R-2511 4B Interagency Concurrence Point Meeting Minutes

Date: April 18, 2018

The 30% Hydraulic Review was held in order to reach agreement on concurrence point 4B for the R-2511 US-17 widening project in Beaufort and Martin Counties. The following items were discussed and conclusions reached:

PROJECT REFERENCE NO. R-2511	SHEET NO. 47
RW SHEET NO.	
ROADWAY DESIGN ENGINEER	HYDRAULICS ENGINEER
DOCUMENT NOT CONSIDERED FINAL UNLESS ALL SIGNATURES COMPLETED

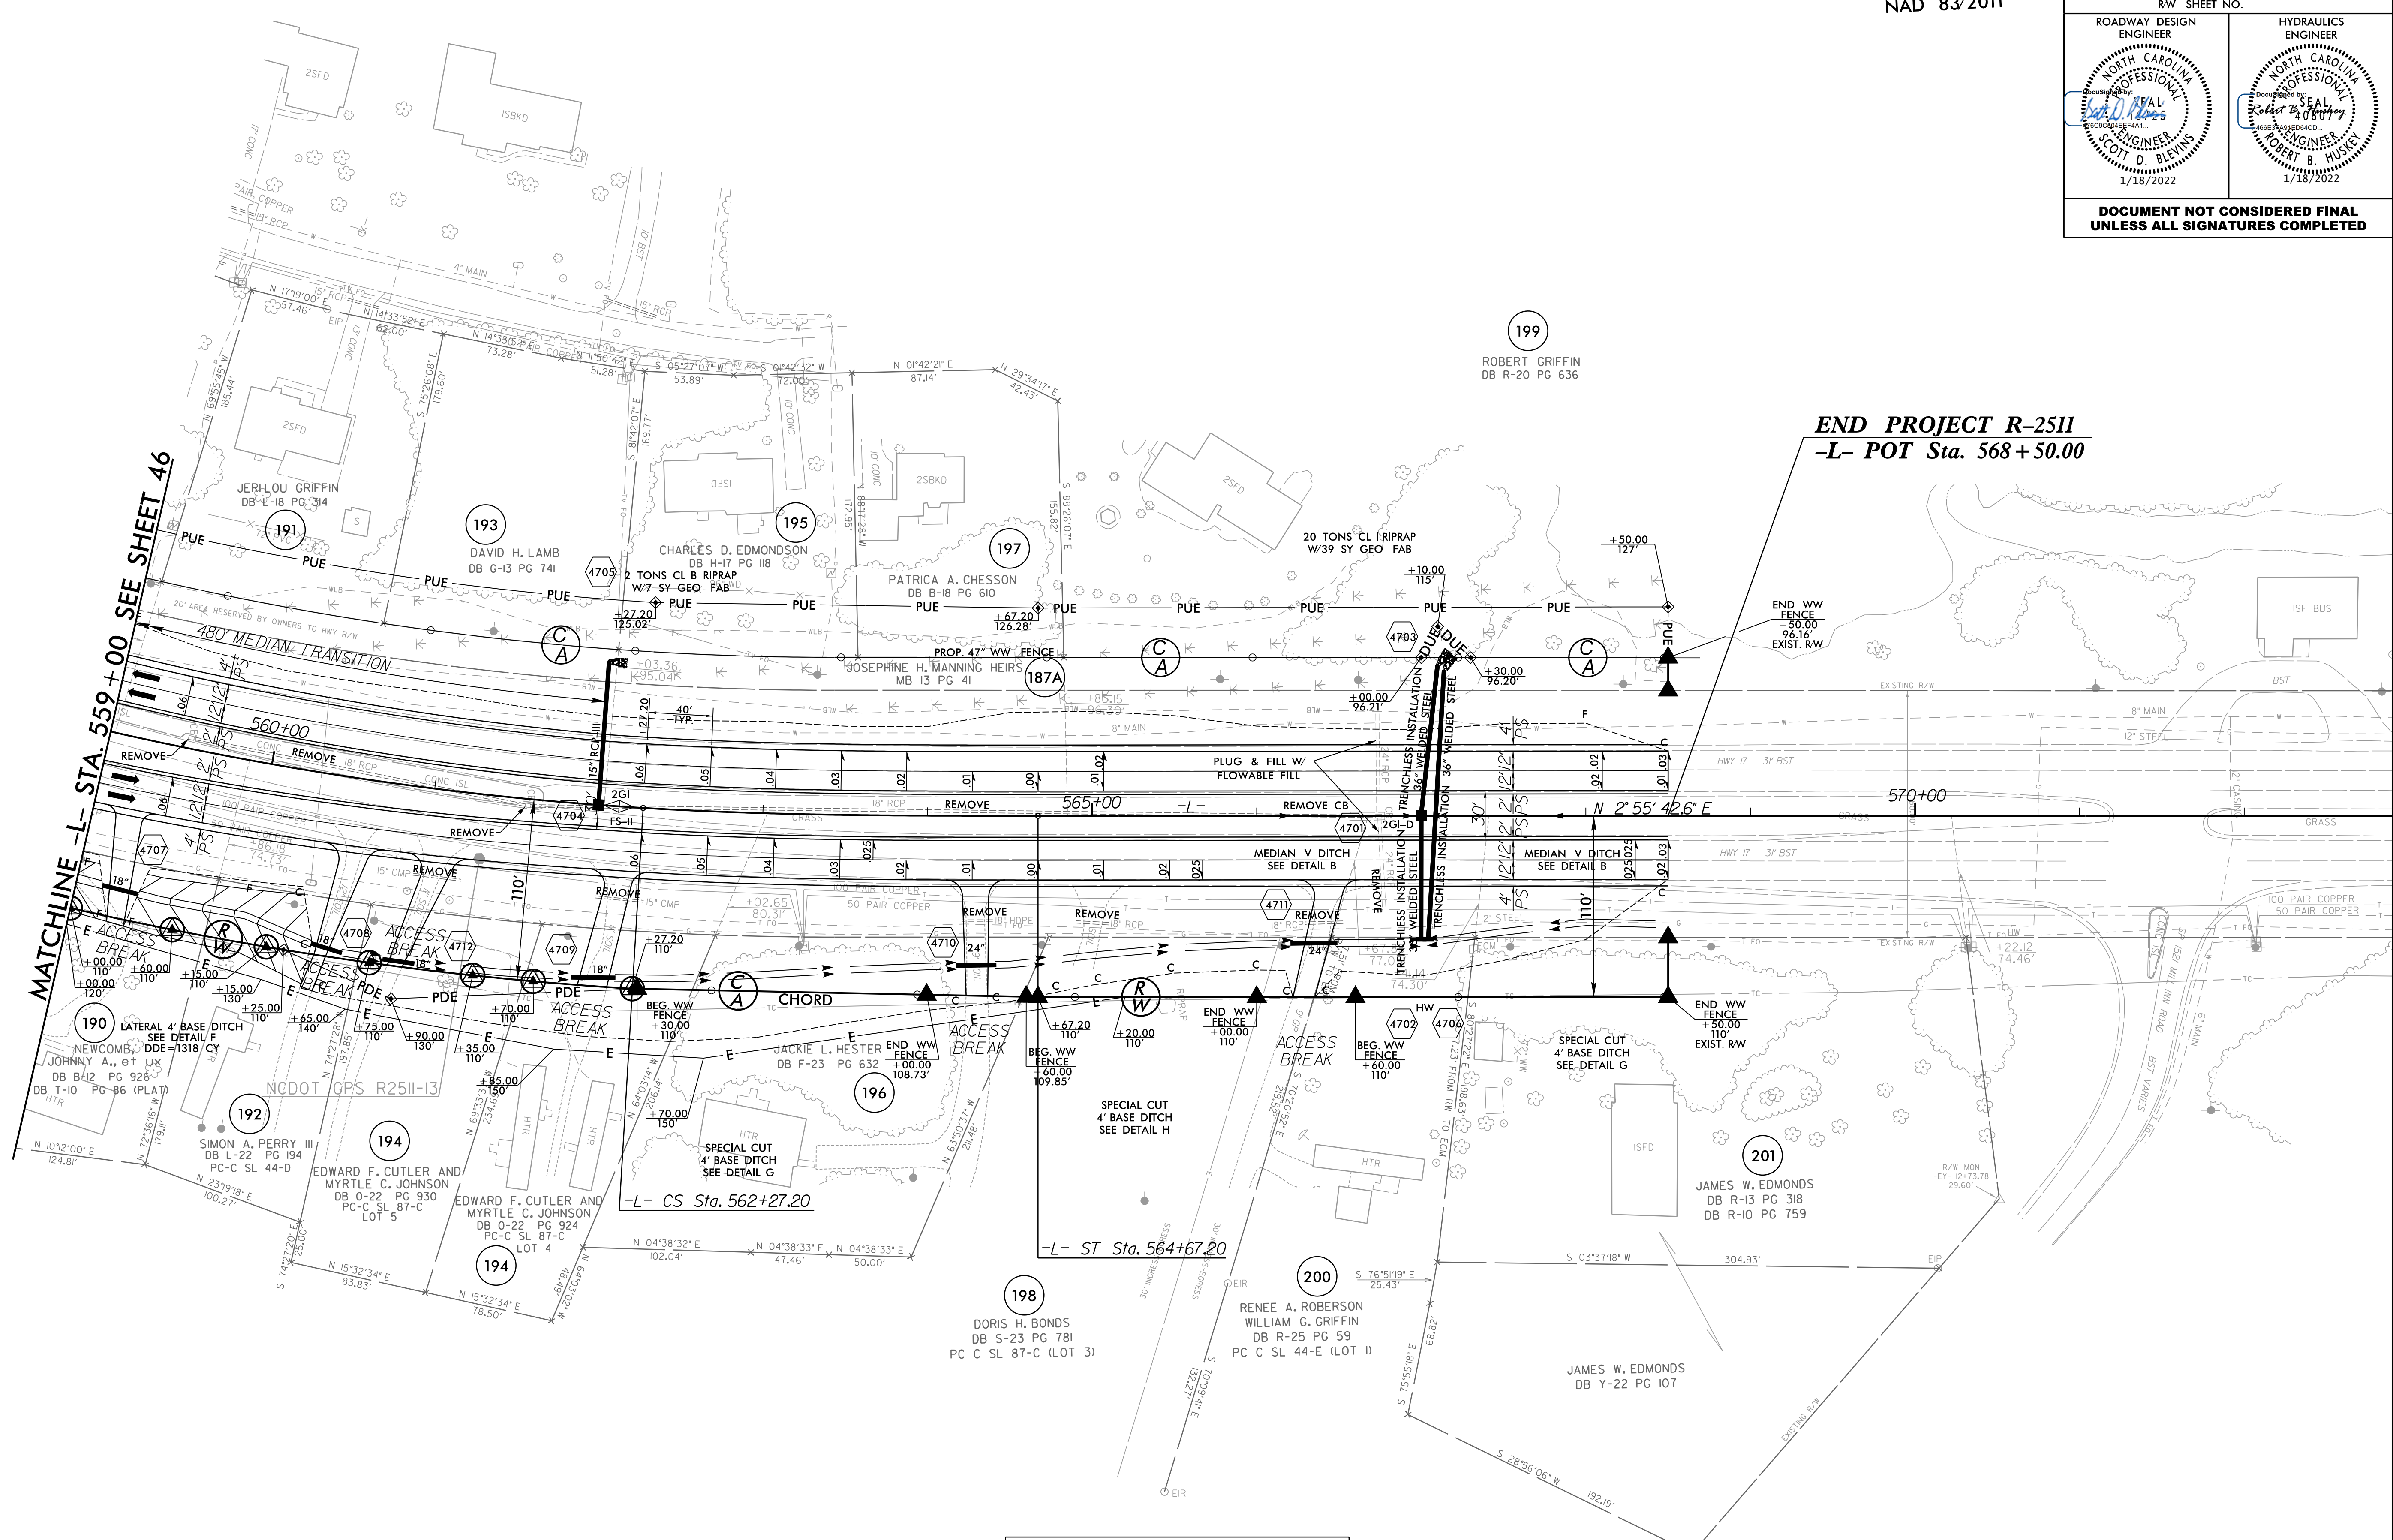
Plan sheet 46-47 (Wetland WI): At this site Wetland WI is delineated from -L- STA. 557+50 to 568+50 LT until it reaches the pond that is adjacent to the roadway facility. There will be wetland impacts stretching from -L- STA. 557+50 to 568+00 LT where the new roadway fill slopes will be encroaching into the wetlands due to the road widening. This wetland was not in the previous WEX file, so the ditch running through it will be removed. Toe projection will be placed only up on the fill slopes where the wetland impacts are to protect the fill slopes from eroding. This will be called out as site 14.
